June 12, 2020

Add PCD File No. WSEO201

RE: Major Amendment – Drainage Letter
Front Range Midway Solar Project
Fountain, CO

6/8/2020 5:52 PM, X:\19-177 FRMW SOLAR - EARLY ASSISTANCE\CIVIL\REPORTS\DRAINAGE\LETTER\CD-DRAIN.MXD DWG

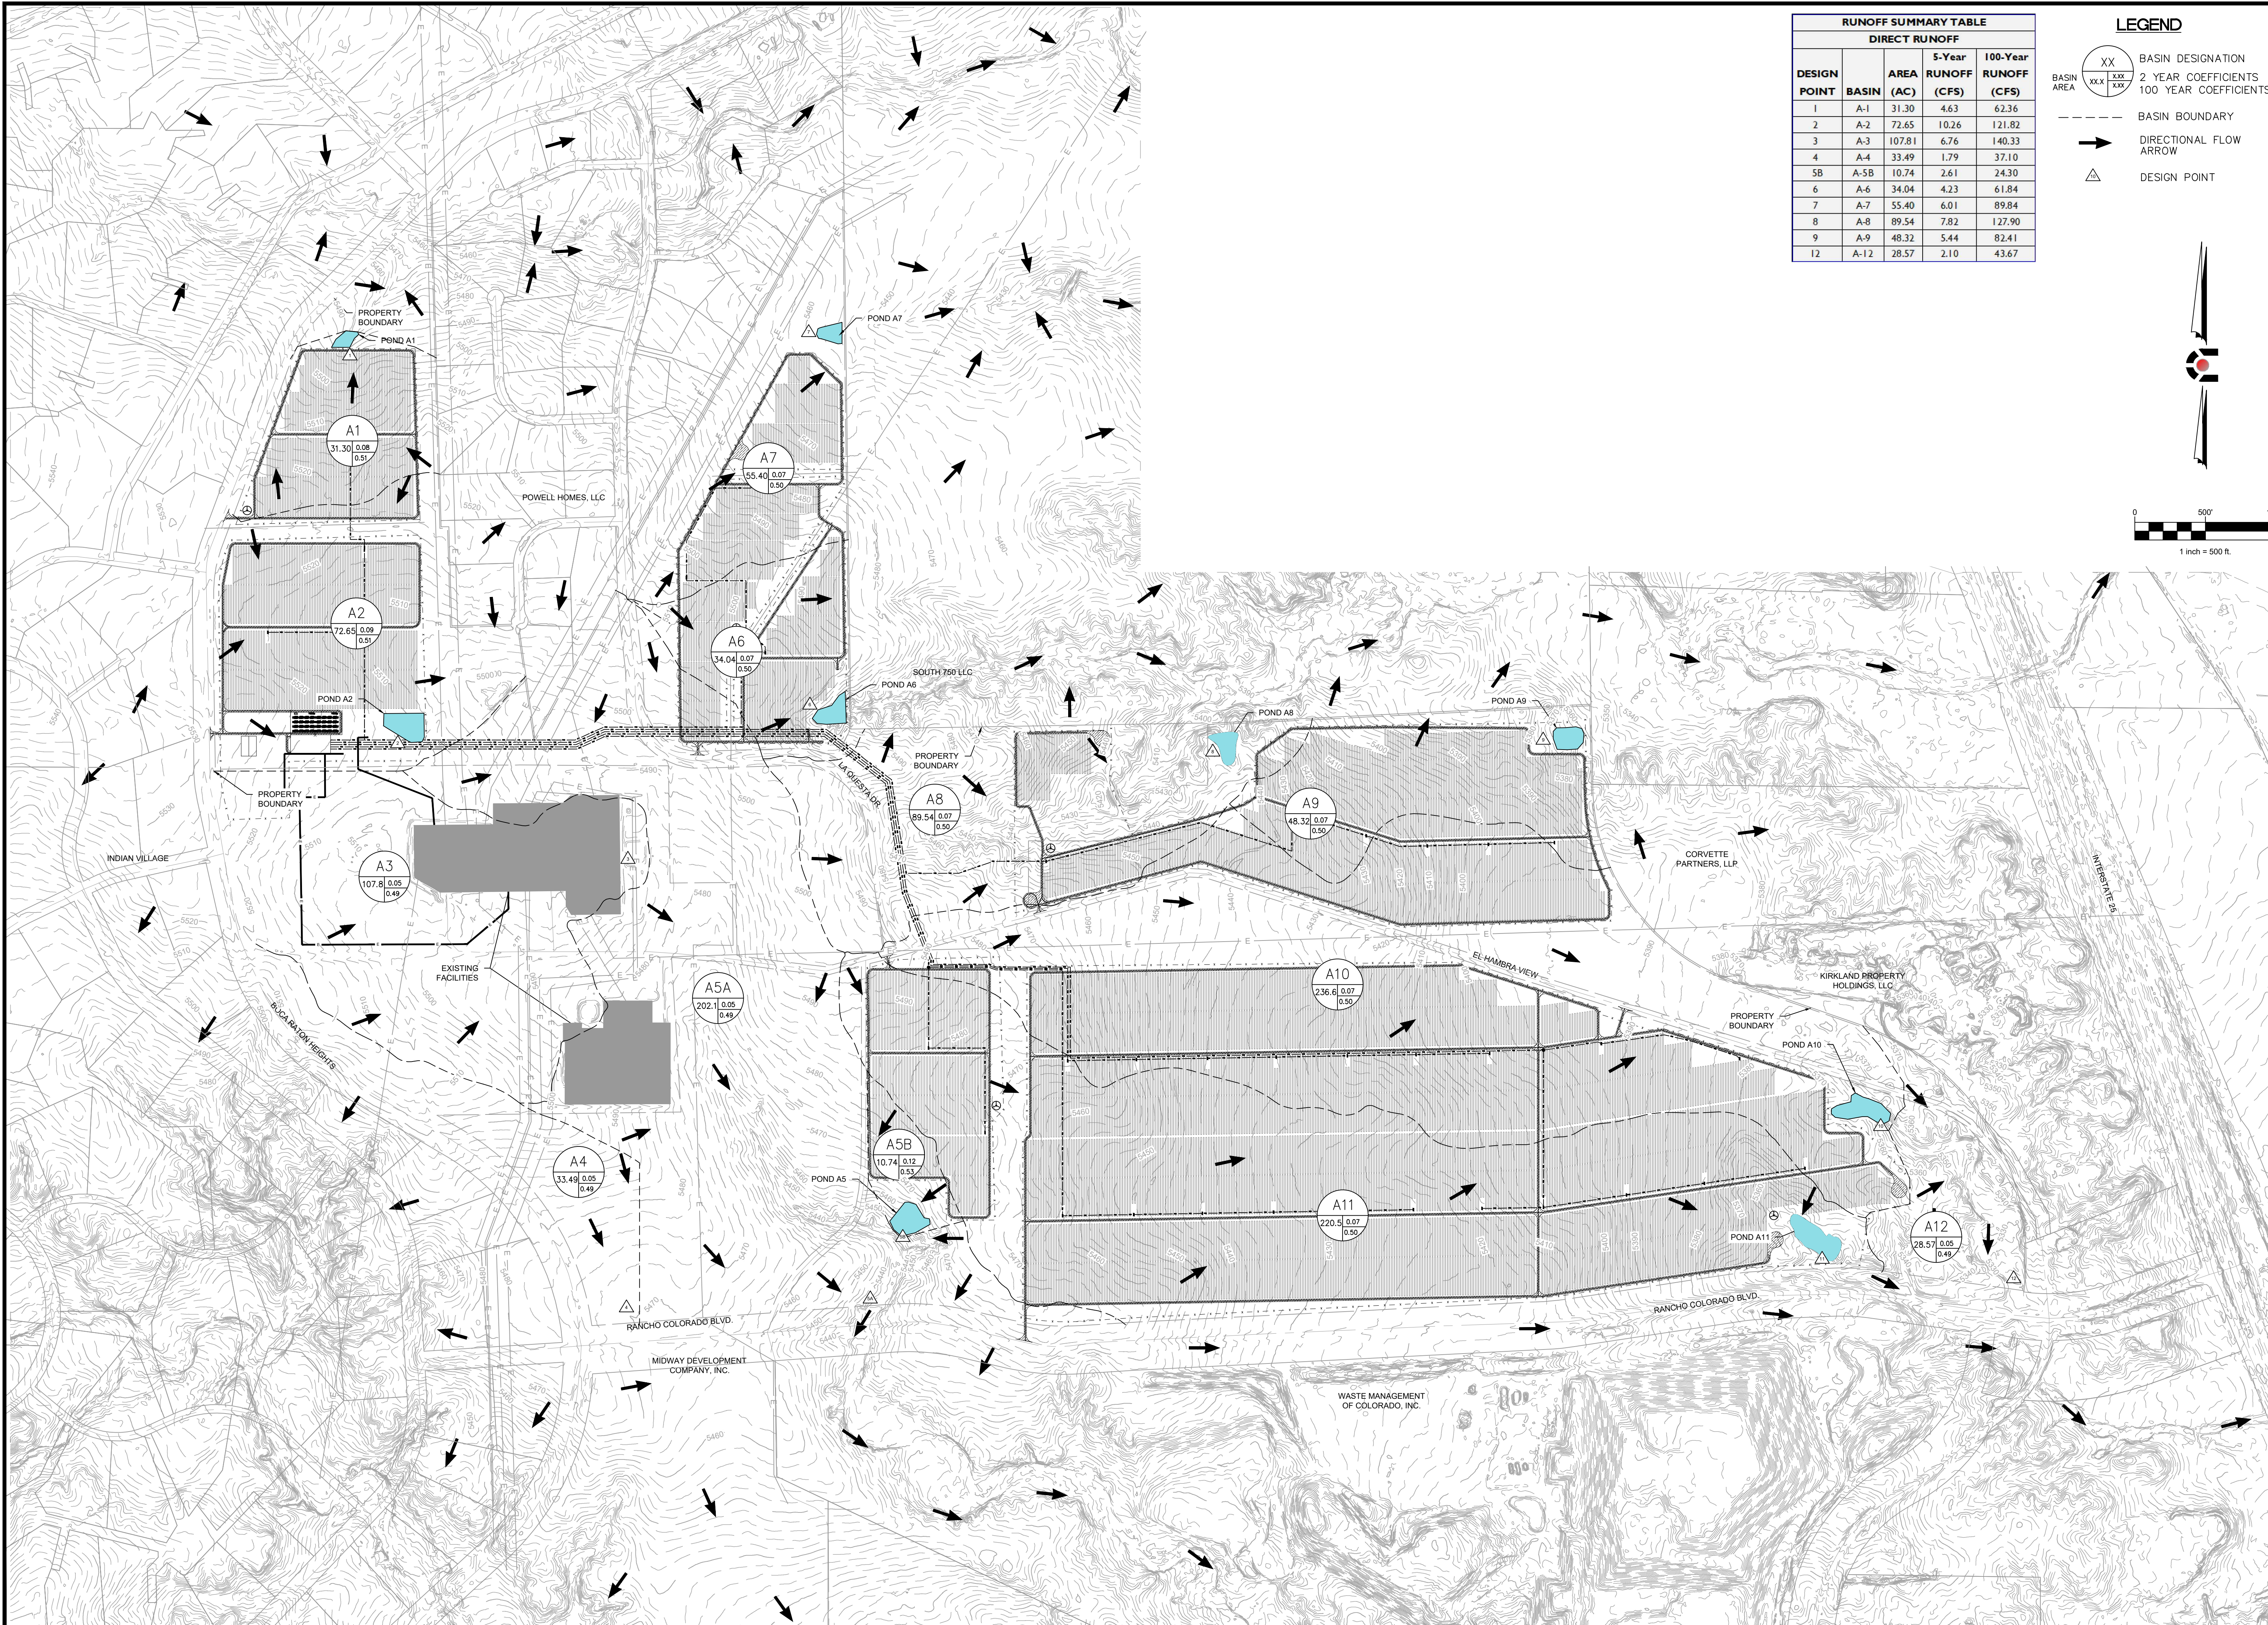
As this basin has been relocated,
please provide a description of the
flow in this basin.
